**Response from Natural England - Stone Curlew**

### **Sunnica response**

Drawing Title  
**FIGURE 10-14C  
 LANDSCAPE MASTERPLAN  
 SUNNICA EAST SITE B**

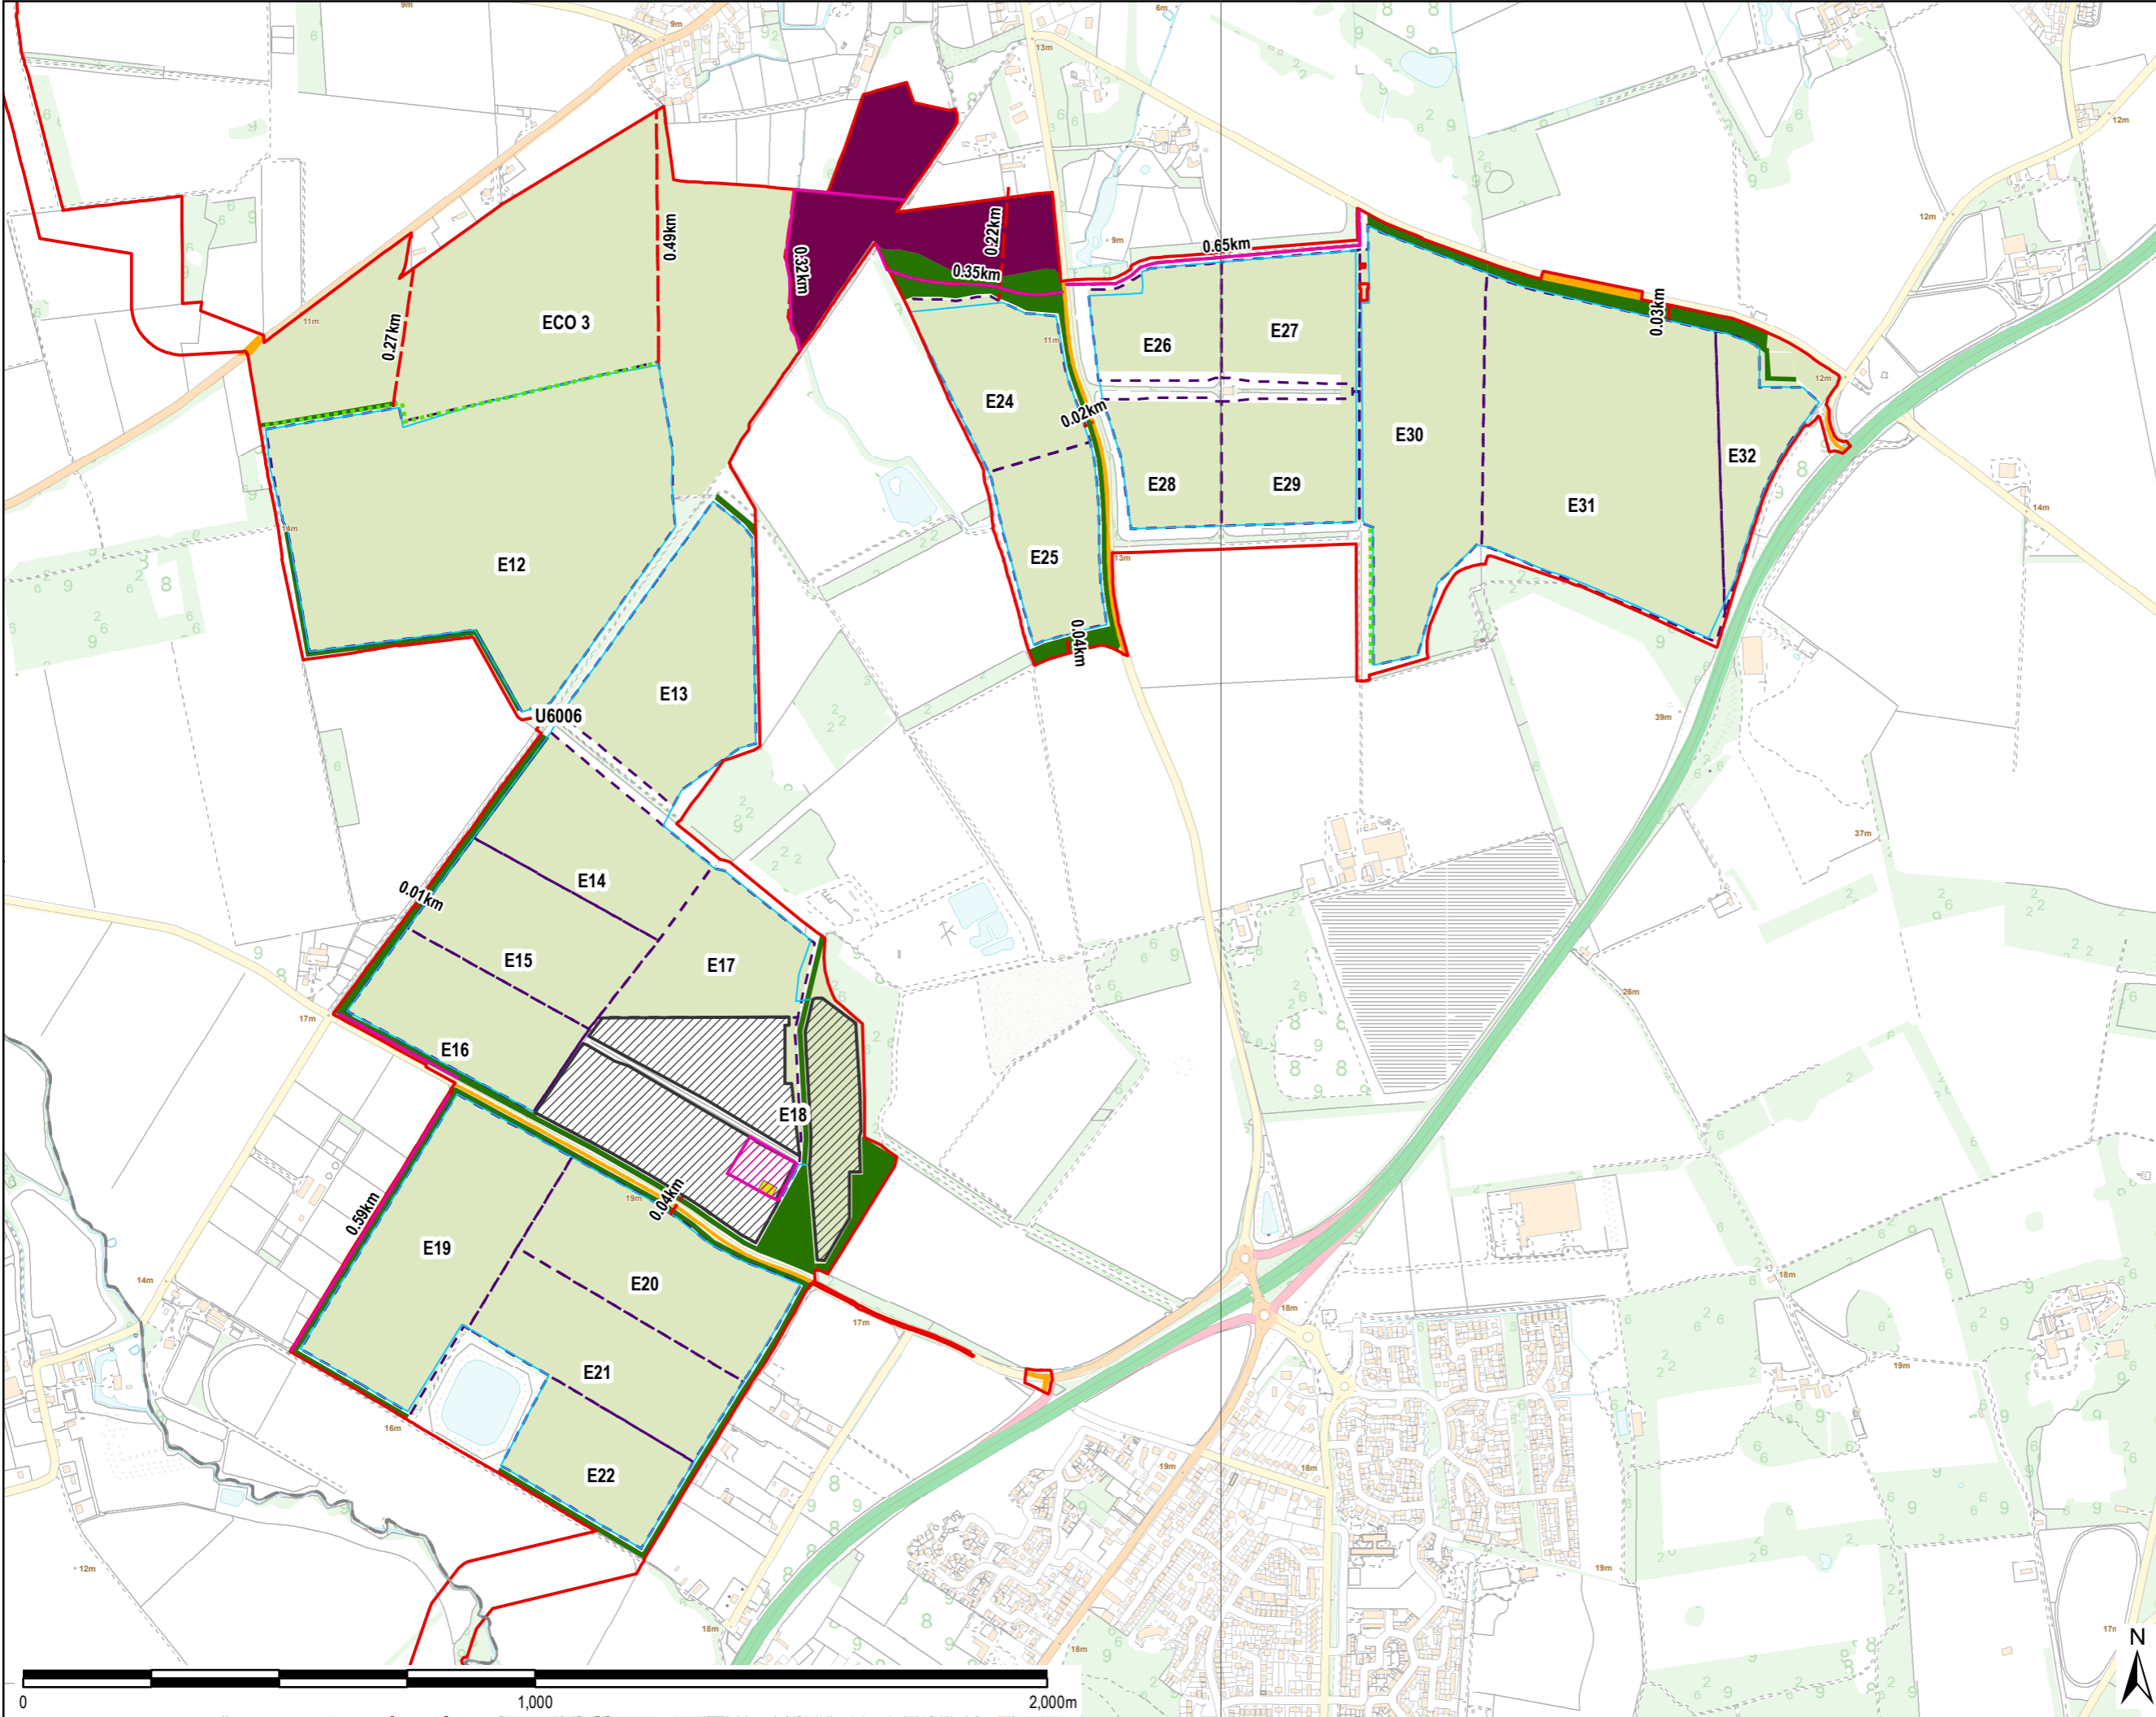
Breckland is a land of open spaces, long vistas and wide skies. This scheme seeks to mask its industrial infrastructure with comparatively small blocks of hedging, totally at odds with the natural Breckland landscape. How successful the screening will be is open to question but it will alter the character of the landscape beyond recognition.

Drawing Title
**FIGURE 10-14B
LANDSCAPE MASTERPLAN
SUNNICA EAST SITE A**

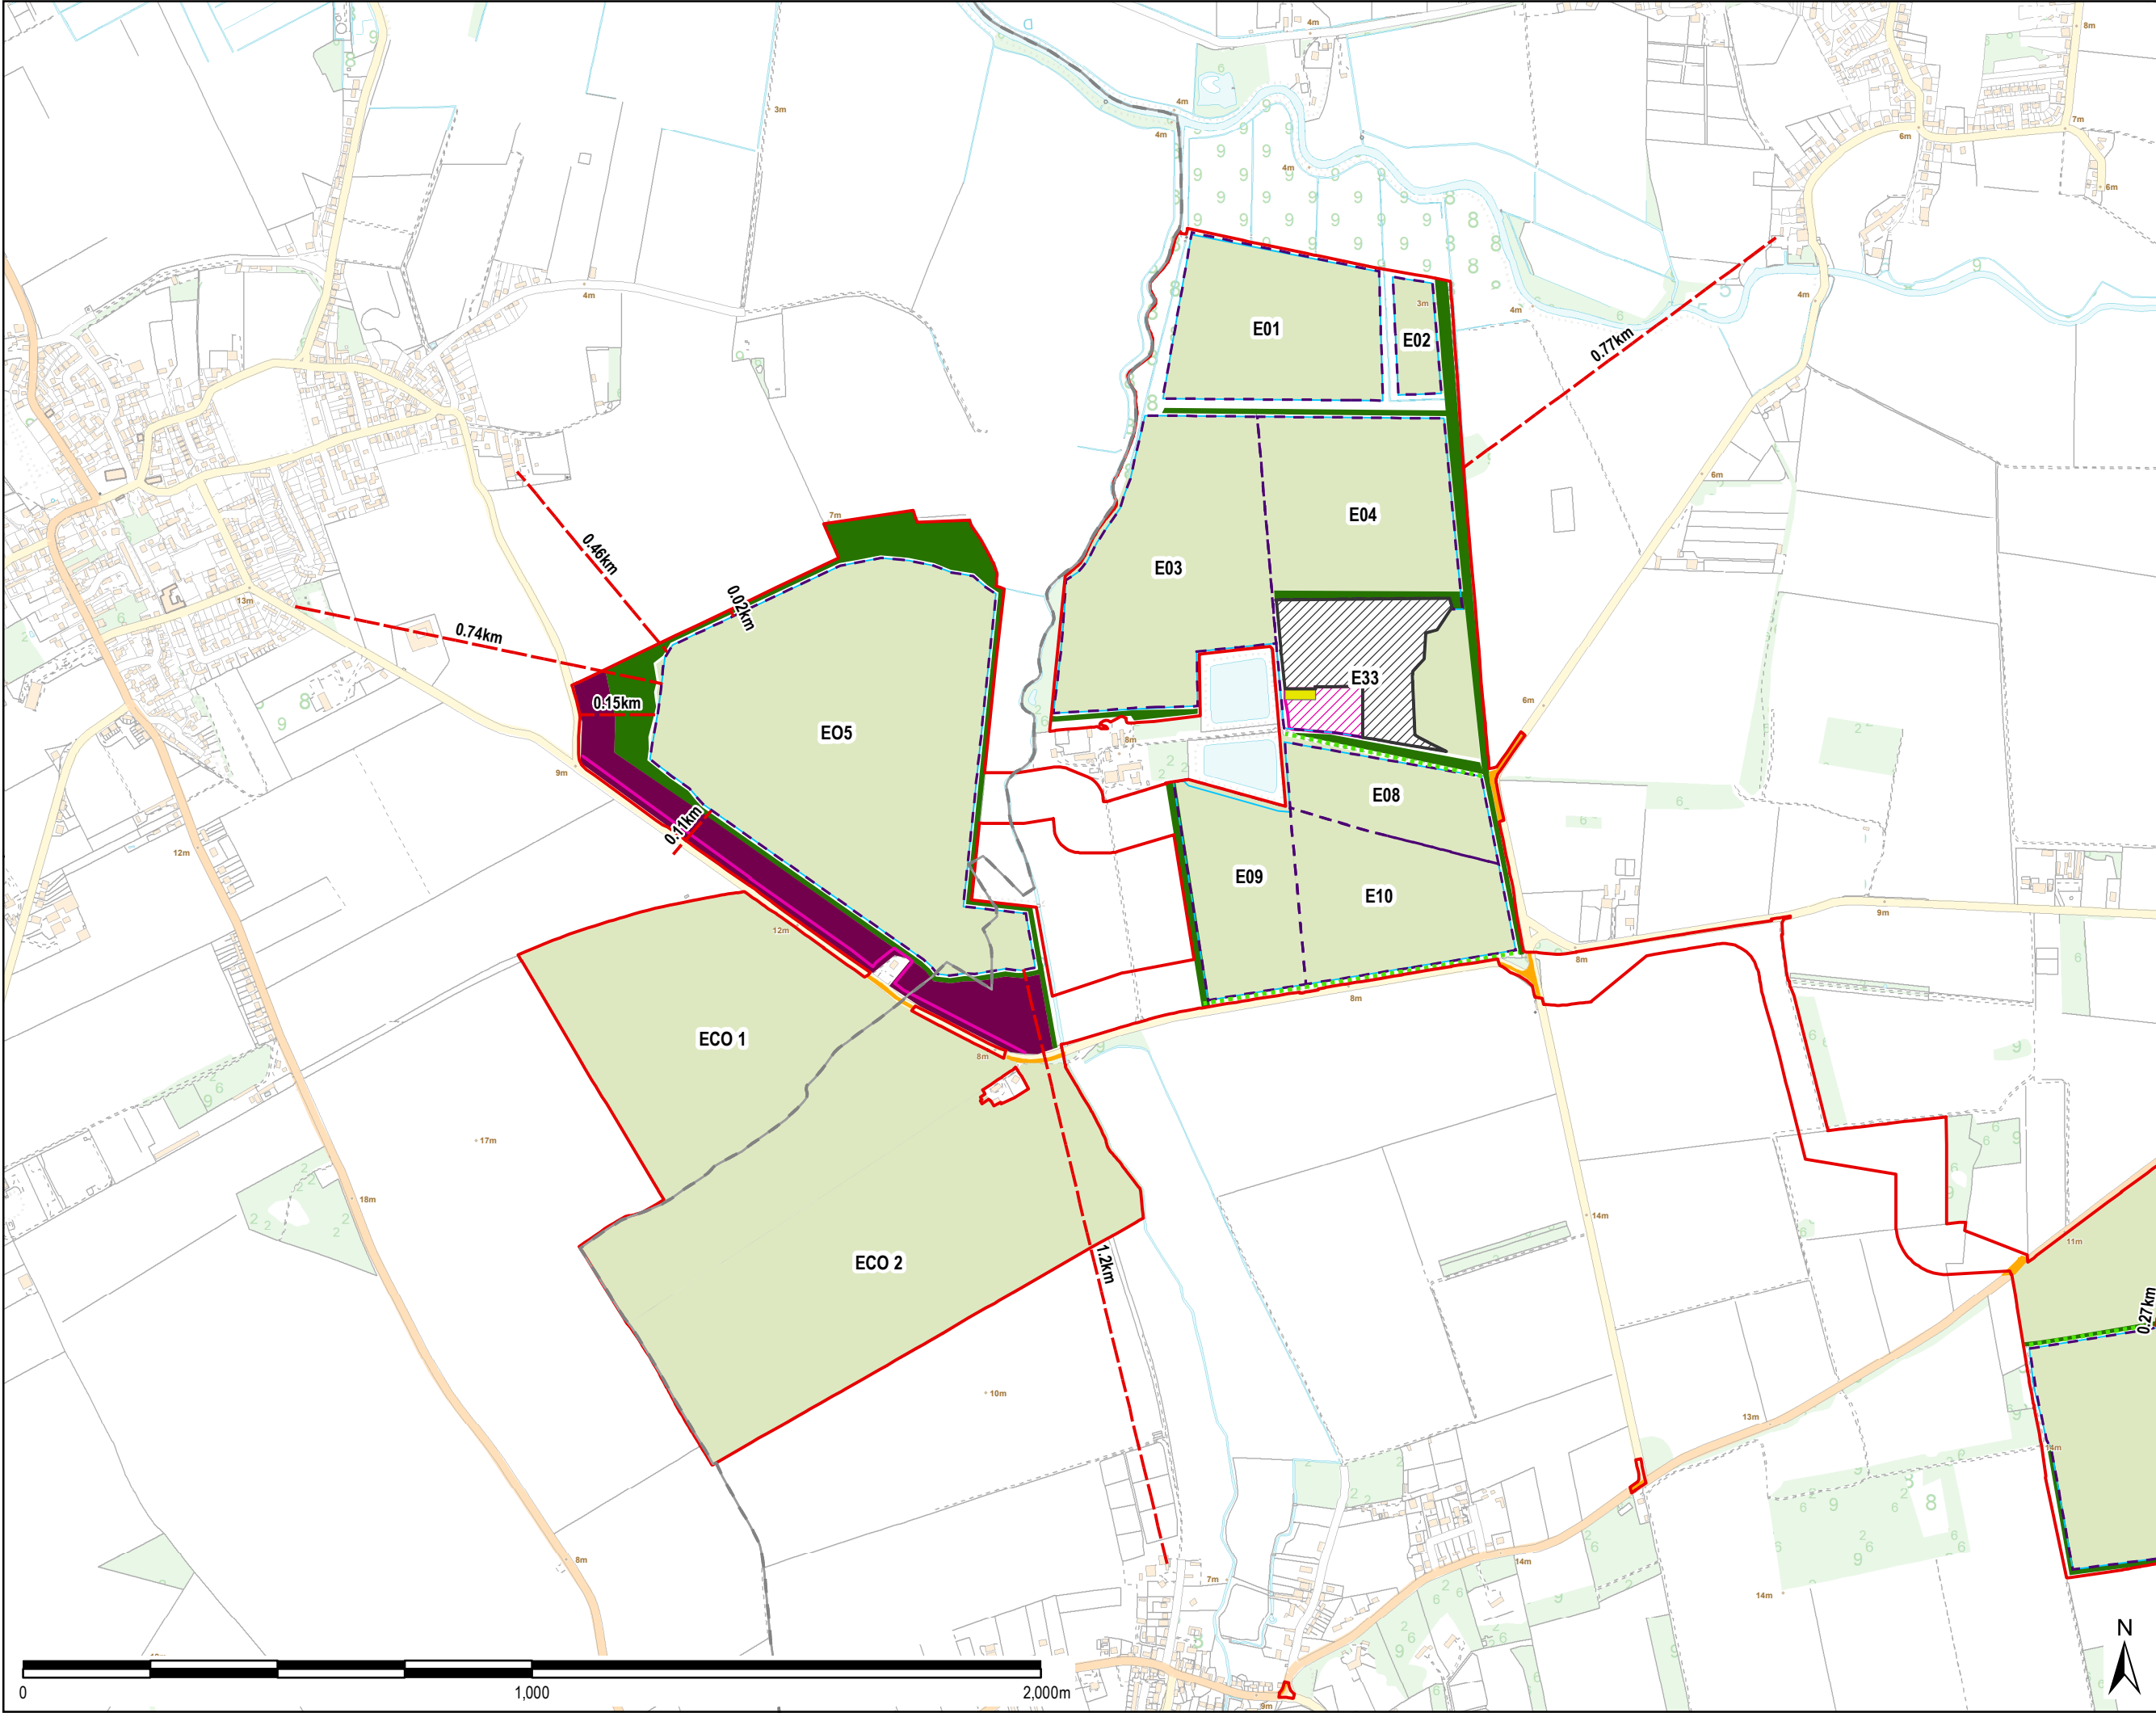
Sunnica's Stone Curlew mitigation area EC02 in East Site A is poorly located given the birds' sensitivity to human presence and disturbance. EC02 abuts Mortimer Lane, a popular PROW and bridleway [REP 2-139, pp 8-10] and only a few hundred metres from E33, the BESS and substation at East Site A.
